2022/1159

Erection of first floor rear extension, single storey front extension, and single storey side extension to dwelling

5 Alexander Gardens, Cawthorne, Barnsley, S75 4EW

Refuse

REAR ELEVATION
AS PROPOSED 1:100

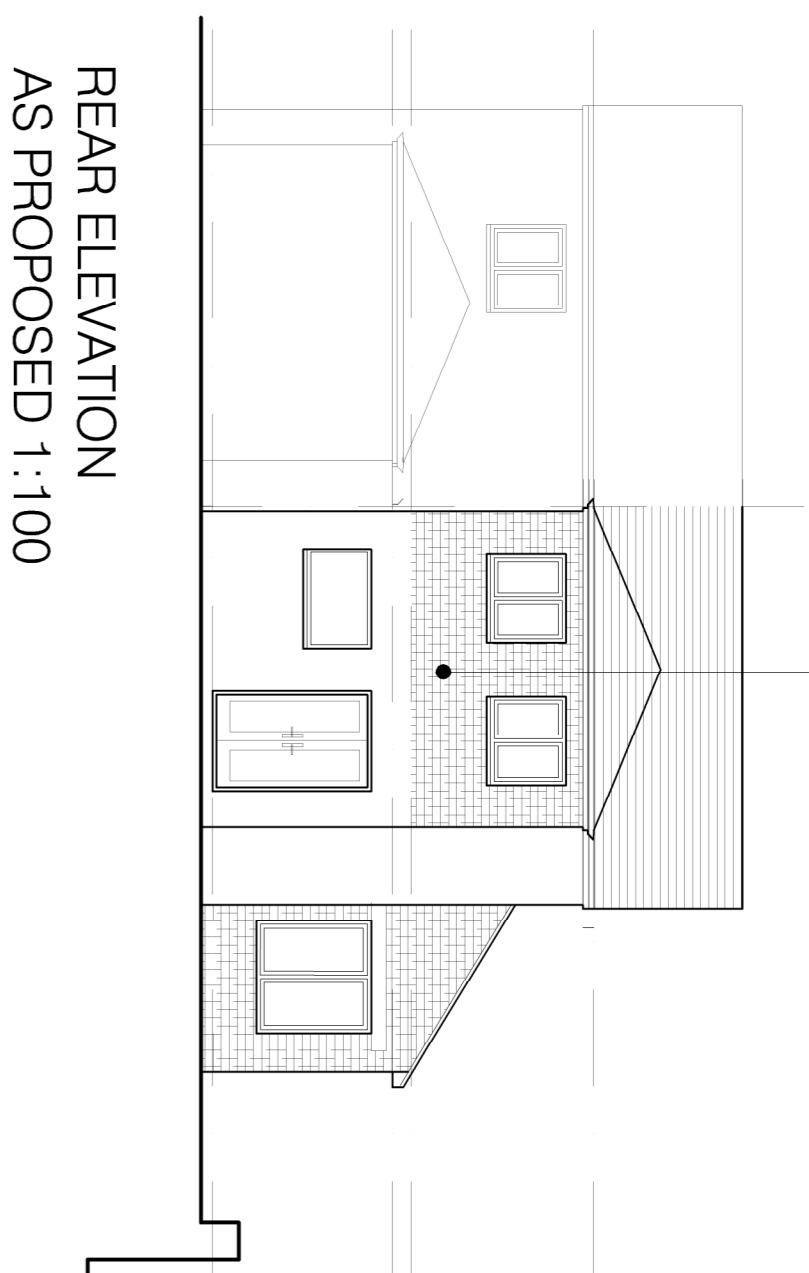
'I feel the two-story part of the proposal is out of keeping, and to a degree intrudes negatively into the setting of South Lodge that is 14.6m to the west. Views of the listed building from the east would be impacted by the two-storey extension. Moreover, a variety of viewpoints within

the setting of the principal elevation (of South Lodge) from the south that contribute strongly to the significance of the listed building would be altered. I'd suggest this introduces some harm and would be avoided by deleting the two-storey element of the proposal.'

This rear first floor extension had now been re-added and the proposal is exactly the same as the original 2022 submission before it was revised. As a result the Conservation Officer has significant concerns with regard to the proposal put forward:-

'I have concerns over this proposal given the obvious setting implications of the adjacent listed building and the prominent conservation area location. Clearly the site is very visible with open views of the building possible in direct context with South Lodge (<https://historicengland.org.uk/listing/the-list/list-entry/1151793>) looking south, west and north when travelling along or standing on Tivy Dale. Clearly, the setting of South Lodge has changed over time from the original construction date of circa 1820. However, some encroachment has taken place by 1948 with elements of the camp and more permanent developments appearing in the vicinity of Tivy Dale / Brook House by 1948. Infill development has continued since then to the present day including the development at Alexander Gardens. The host dwelling appears to have been constructed following approval of B/82/0854/PR or possibly B/83/1619/PR and therefore dates to the 1980's. My feeling is that the courtyard that 5 Alexander Gardens is part of is a relatively positive presence in the setting of South Lodge and the conservation area. In terms of its architecture, scale, and details the building is quite recessive but complementary being stone built, with stone (artificial – maybe Hardrow's or Greys Artstone) and the later concrete interlocking tiles to the roof of the rear single storey extension.

Fenestration is also restrained and low key and overall, the buildings at Alexander Gardens form a complementary courtyard type development that reflects vernacular and historic precedents in the area. Critically, whilst modern, it is currently not strongly intrusive into the setting of the listed building or the conservation area having a gentle enclosure around the courtyard. There are single story elements (porches / canopies) with single pitch roofs inside the courtyard and rear extensions on the outside of the courtyard with pitched roofs. Importantly the current arrangement at Alexander Gardens has a sympathetic hierarchy with the more visible single-story elements and extensions not dominating the main dwellings. In that regard I feel the two-story part of the proposal is out of keeping and intrudes negatively into the setting of South Lodge that is 14.6m to the west. Views of the listed building from the east would be impacted by the two-storey extension. Moreover, a variety of viewpoints within the setting of the principal elevation (of South Lodge) from the south that contribute strongly to the significance of the listed building would be negatively impacted. I'd suggest this introduces harm to the significance of the listed building setting. This would be avoided by deleting the two-storey element of the proposal.

Given the above, the proposed amended first floor and single storey extensions are unacceptable in terms of scale, design and visual amenity and would not preserve the character of the Conservation Area and would harm the setting of the adjacent Grade II Listed

As can be seen on the drawing below the first-floor window to the adjacent dwelling is set a distance away from the proposed first floor extension by approximately 3.5m. The proposed extension would have a limited projection of 3m which is in line with the guidance set within the SPD. Given the above it is not felt that there would be any significant overshadowing or overbearing impact from the proposed two storey extension, in order to warrant a refusal of planning permission on this basis.

SIDE ELEVATION
AS PROPOSED 1:100

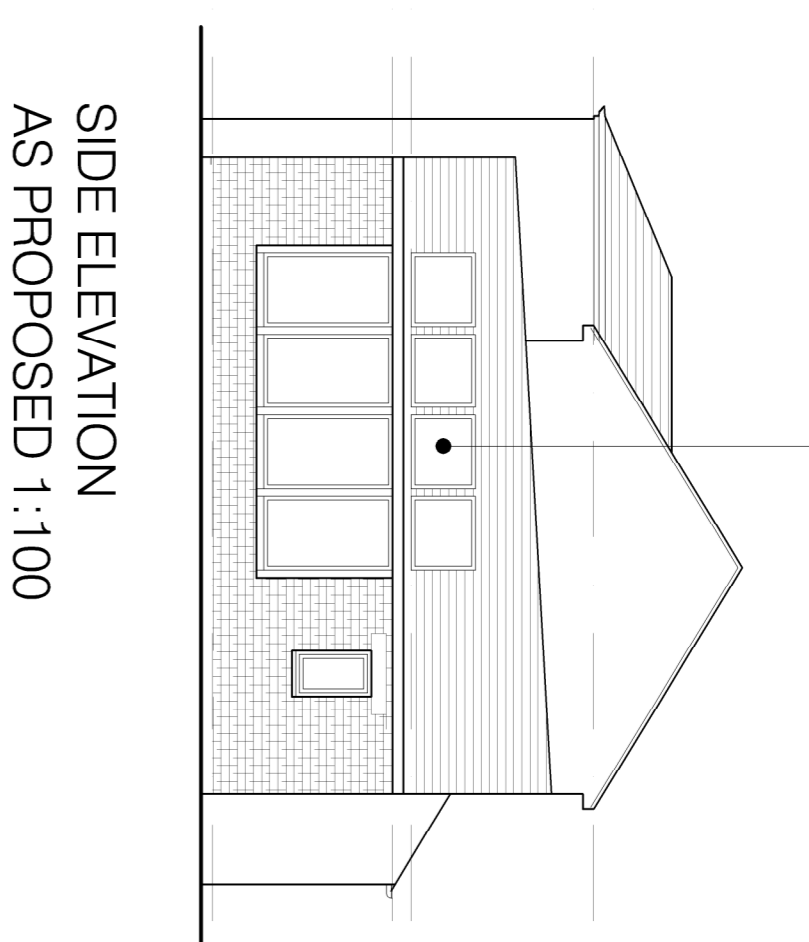
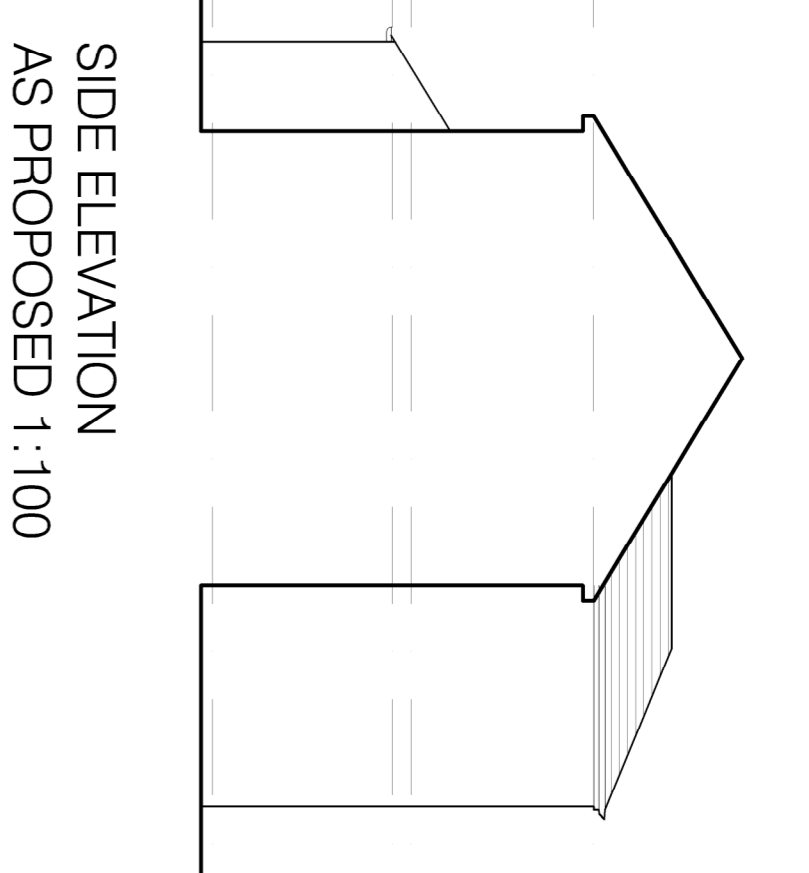
The front and side extensions are less problematic and broadly speaking I do not object. However, the roof glazing of the side lean to would be better as a couple of conservation rooflights to reduce intrusion into the setting and its footprint would likely require reduction if the two-storey element were omitted. The rear two storey element is in my view unacceptable due to the setting issues described above.'
